31 January 2017

RE: SSD-5144 MOD 4 Response to Submissions Letter Report

Set out below is Centennial Mandalong's response to matters raised following public exhibition of the SSD-5144 Modification 4 Statement of Environmental Effects (SEE). A formal response to matters raised was requested by the Department of Planning and Environment (DP&E) in correspondence dated 20 December 2016.

Property 73 - 100 year ARI Storm Event:
Maximum Flood Depth Pre Mining Landform

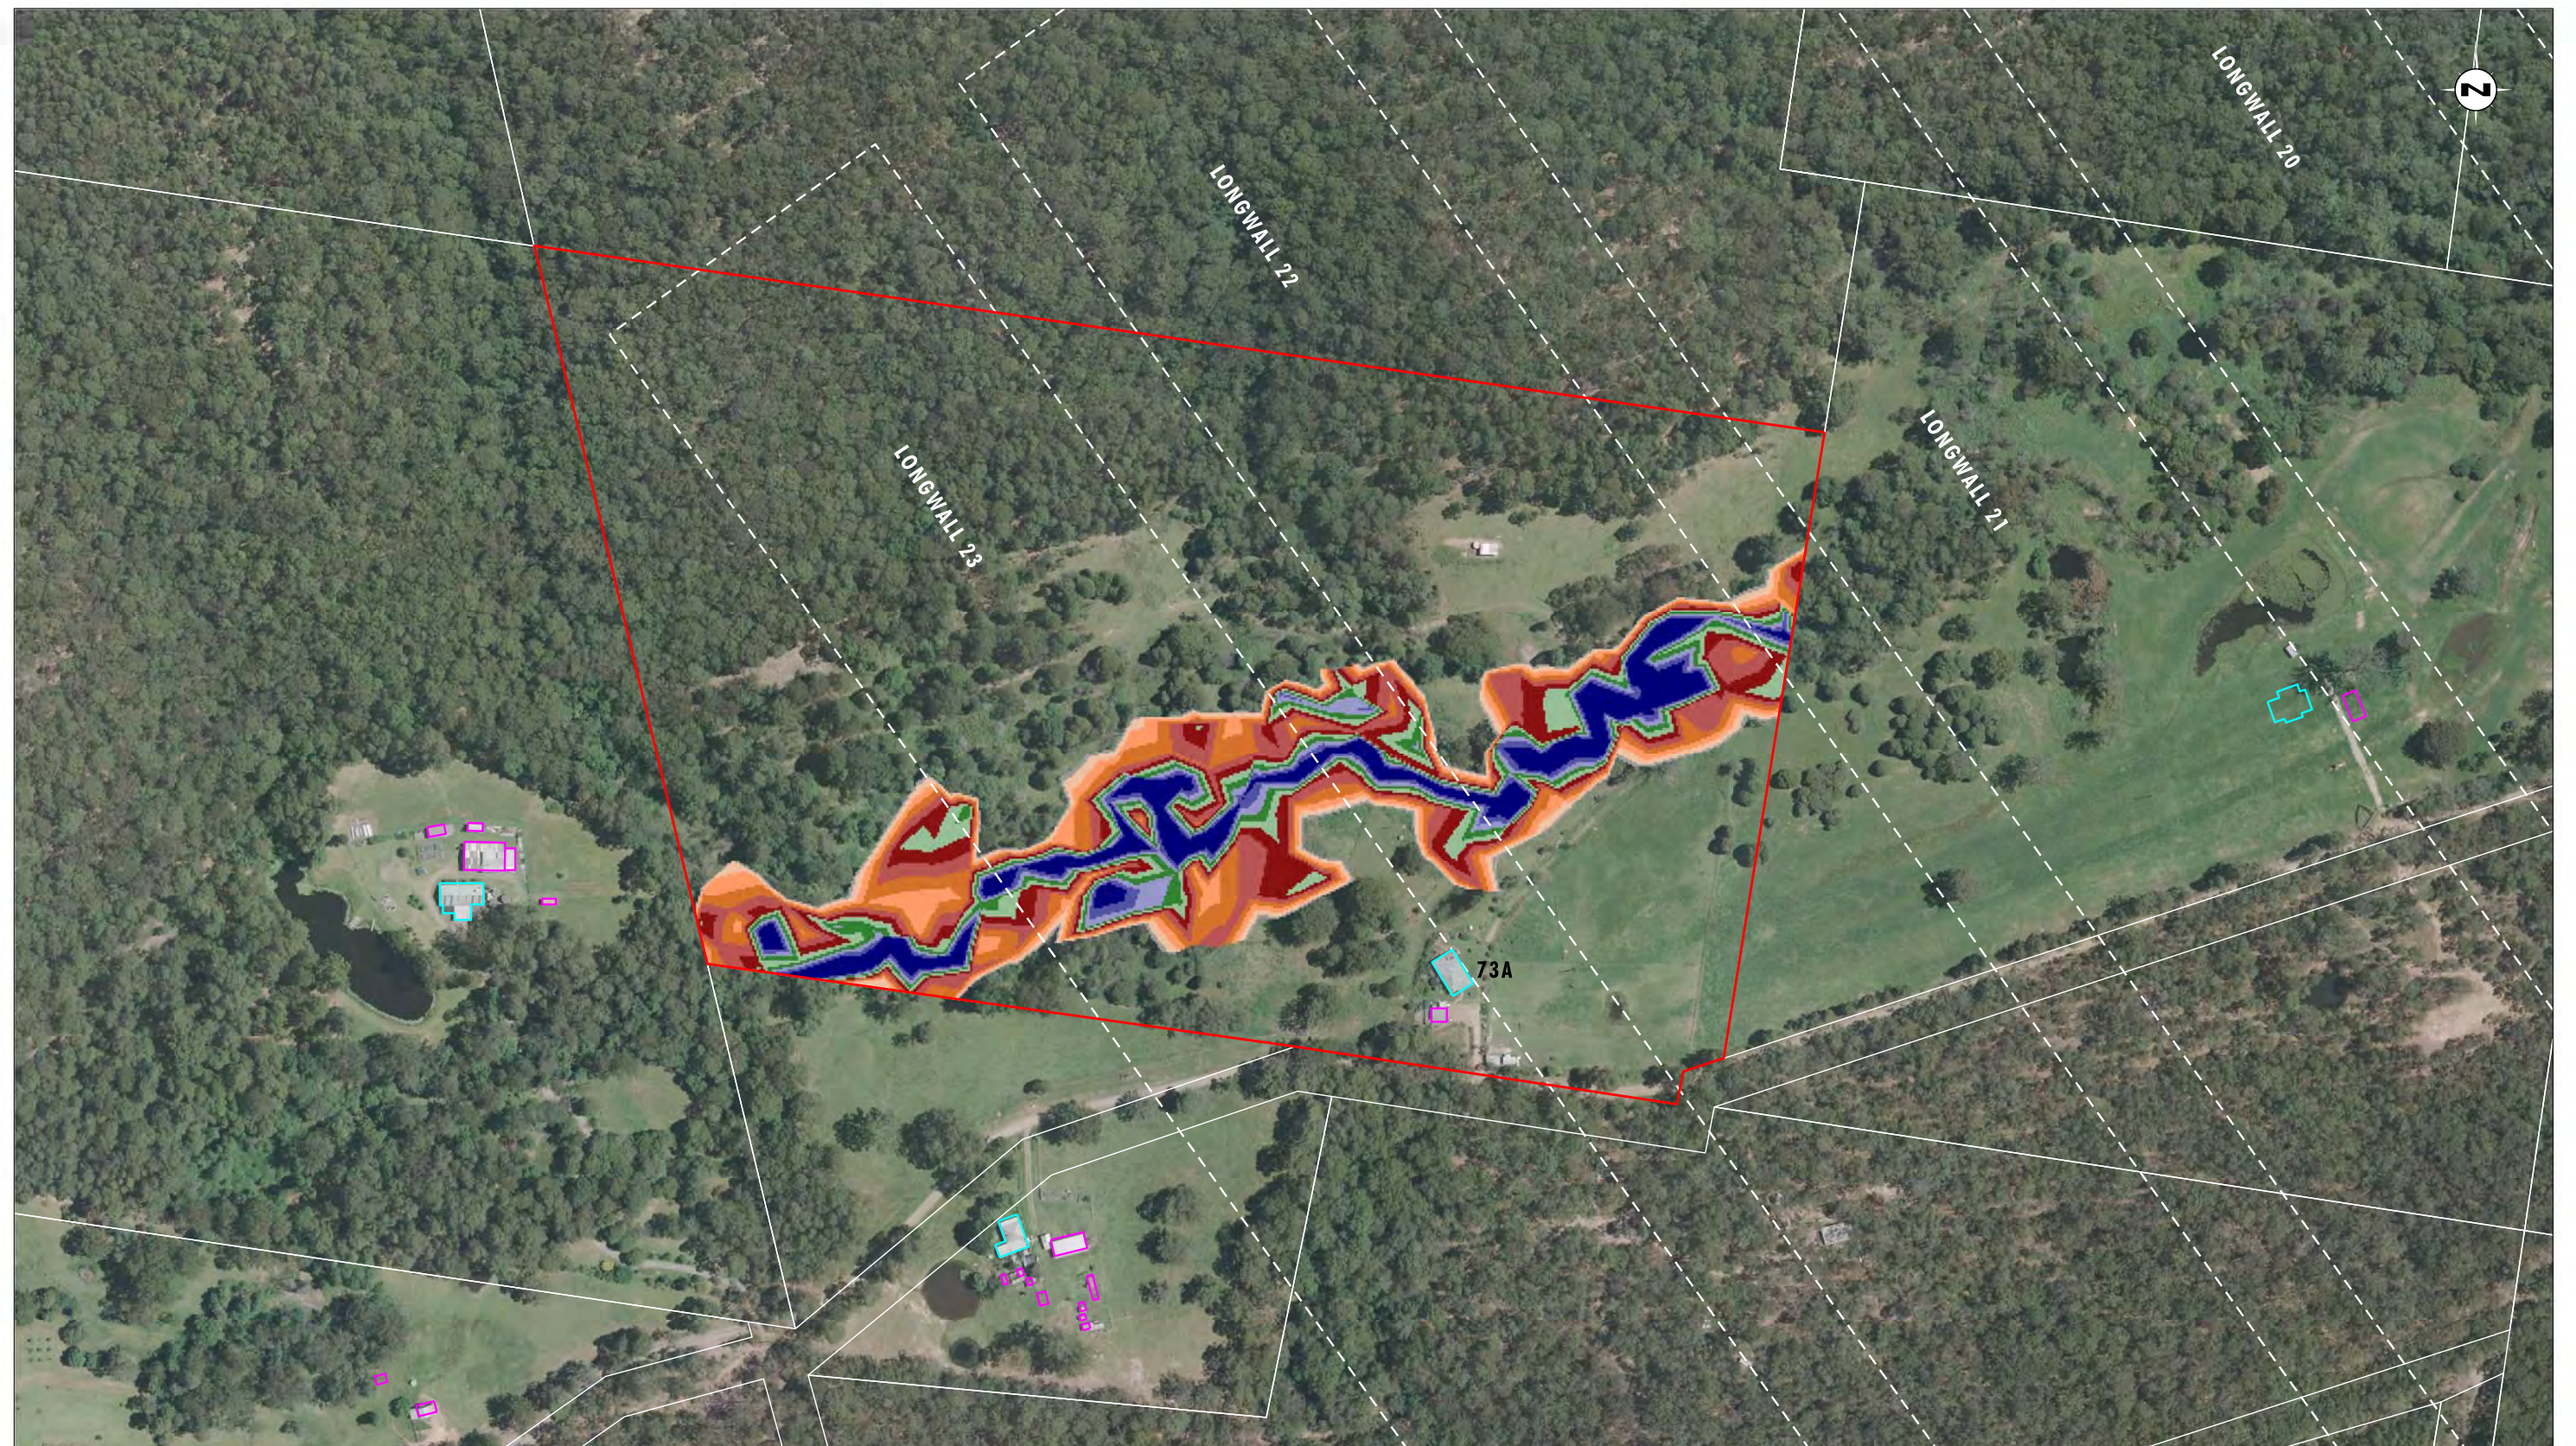
<p>Neither property 73 or 206 are predicted to be adversely affected flood-wise by the modification. OEH has no objection to the current application.</p> <p>The water assessment shows that the previous approval already has, or soon will have, an adverse impact on some private properties from increased flood frequency. Granting approval without indemnity transfers liability from the mine to the NSW Government. This is not supported by OEH.</p> <p>The lack of adequate survey of the project area undertaken to date is problematic. While the impacts of mine subsidence from extended longwall panels 22 and 23 and likely to be minor, they may not be if poorly known faults, shear zones or other geological structures are intersected that transfer more of the mining void to the surface. Therefore for this project OEH recommends the following conditions of consent.</p> <ul style="list-style-type: none"> • That prior to mining commencing, the biodiversity value of the area is quantified by appropriate survey, or if that is not possible then that the proponent commissions an expert report on the threatened biodiversity values of the site, in accordance with the Framework for Biodiversity Assessment. • That any harm to threatened biodiversity caused by the mining of the new longwall panel areas is assessed by the Framework for Biodiversity Assessment, and, if required, offset in accordance with the NSW Biodiversity Offsets Policy for Major Projects.
